# **M60/M62/M66 Simister Island Interchange**

**TR010064**

**ANNEX R: Non-statutory supplementary targeted  
consultation - Update Letters (August 2023)**

### **M60/M62/M66 Simister Island Interchange scheme update**

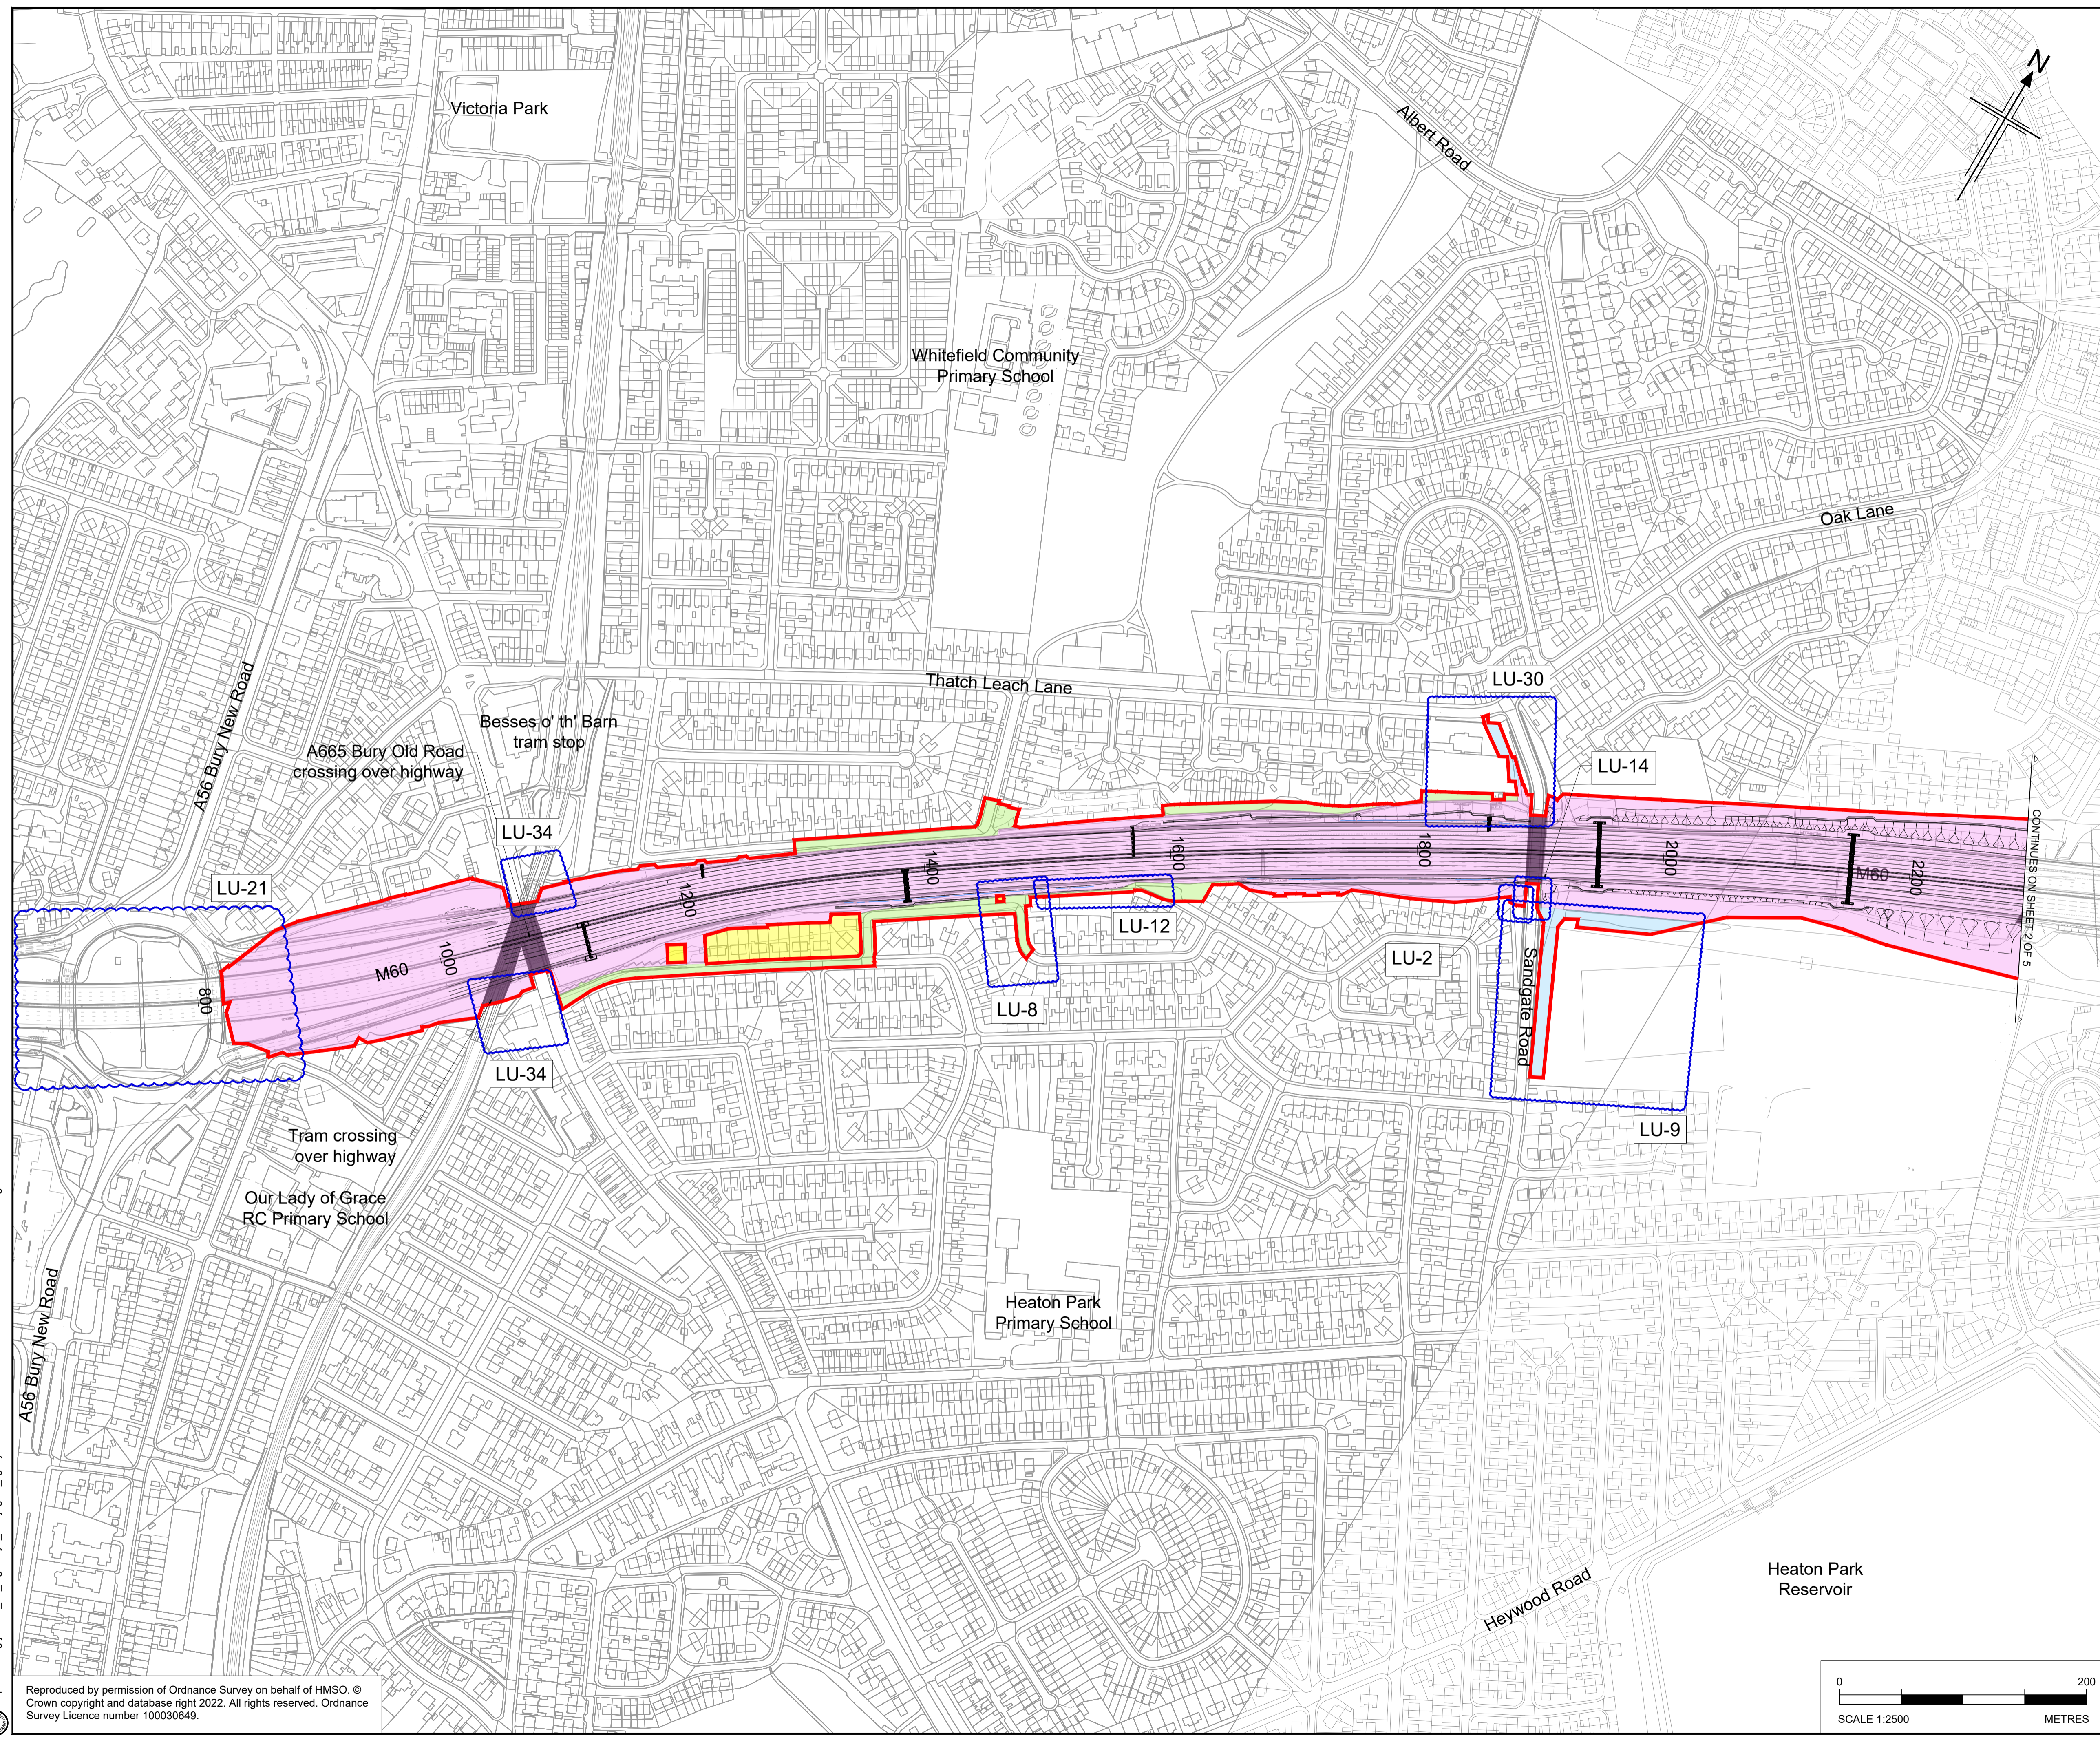
**LU-34:** Two sections of land, the first located east of the A665 Bury Old Road and north of the M60 westbound, the second located west of the A665 Bury Old Road and south of the M60 westbound. Both sections of land previously identified for permanent acquisition removed from scheme red line boundary as no longer required within the scheme design (See LU-34 image and Map Book - Land Use Plan Sheet 1 of 5)

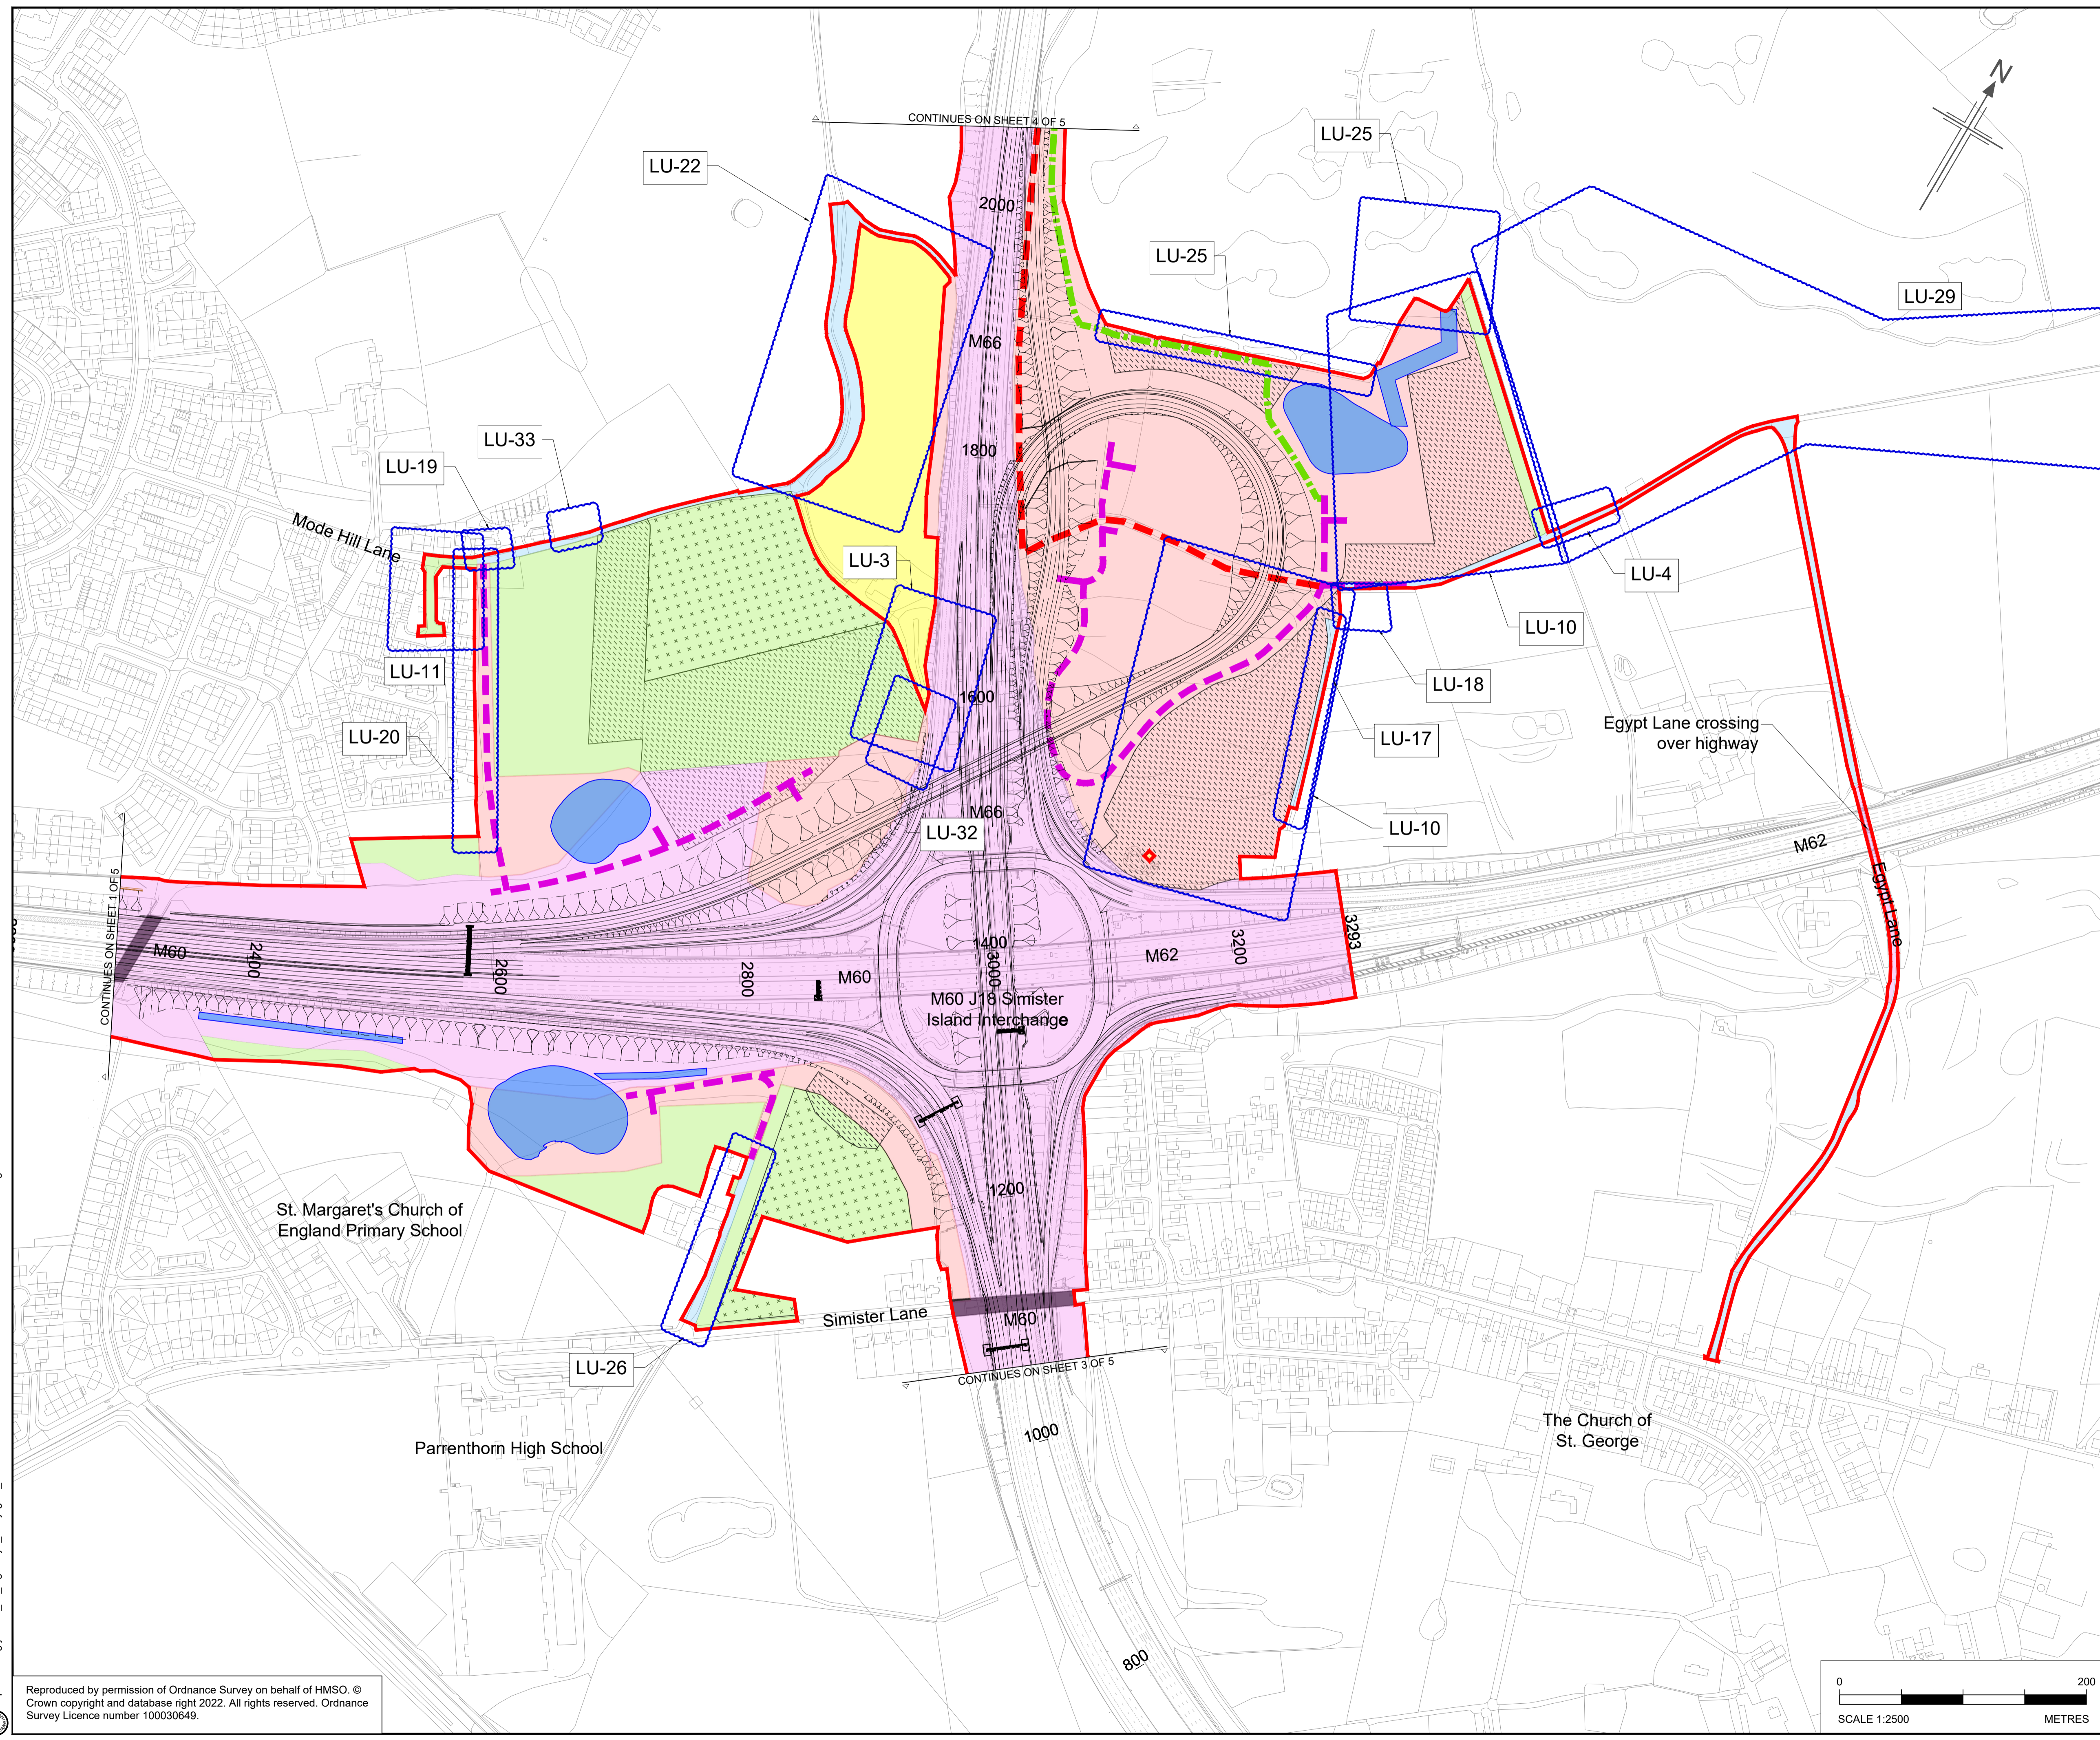
**LU-19:** Small scheme red line boundary change located west of the M66 northbound on Mode Hill Lane. This update is to allow alignment with current land ownership boundaries and to ensure the contractor has sufficient space to access Mode Hill Lane (See LU-19 image and Map Book - Land Use Plan Sheet 2 of 5)

**LU-32:** Small section of land situated west of M66 northbound. Previously identified as in our ownership, has been updated to reflect private ownership and requirement for permanent acquisition (See LU-32 image and Map Book - Land Use Plan Sheet 2 of 5)

**LU-33:** Small scheme red line boundary change located west of the M66 northbound on Mode Hill Lane, to allow alignment with current land ownership boundaries. (See LU-33 image and Map Book - Land Use Plan Sheet 2 of 5)
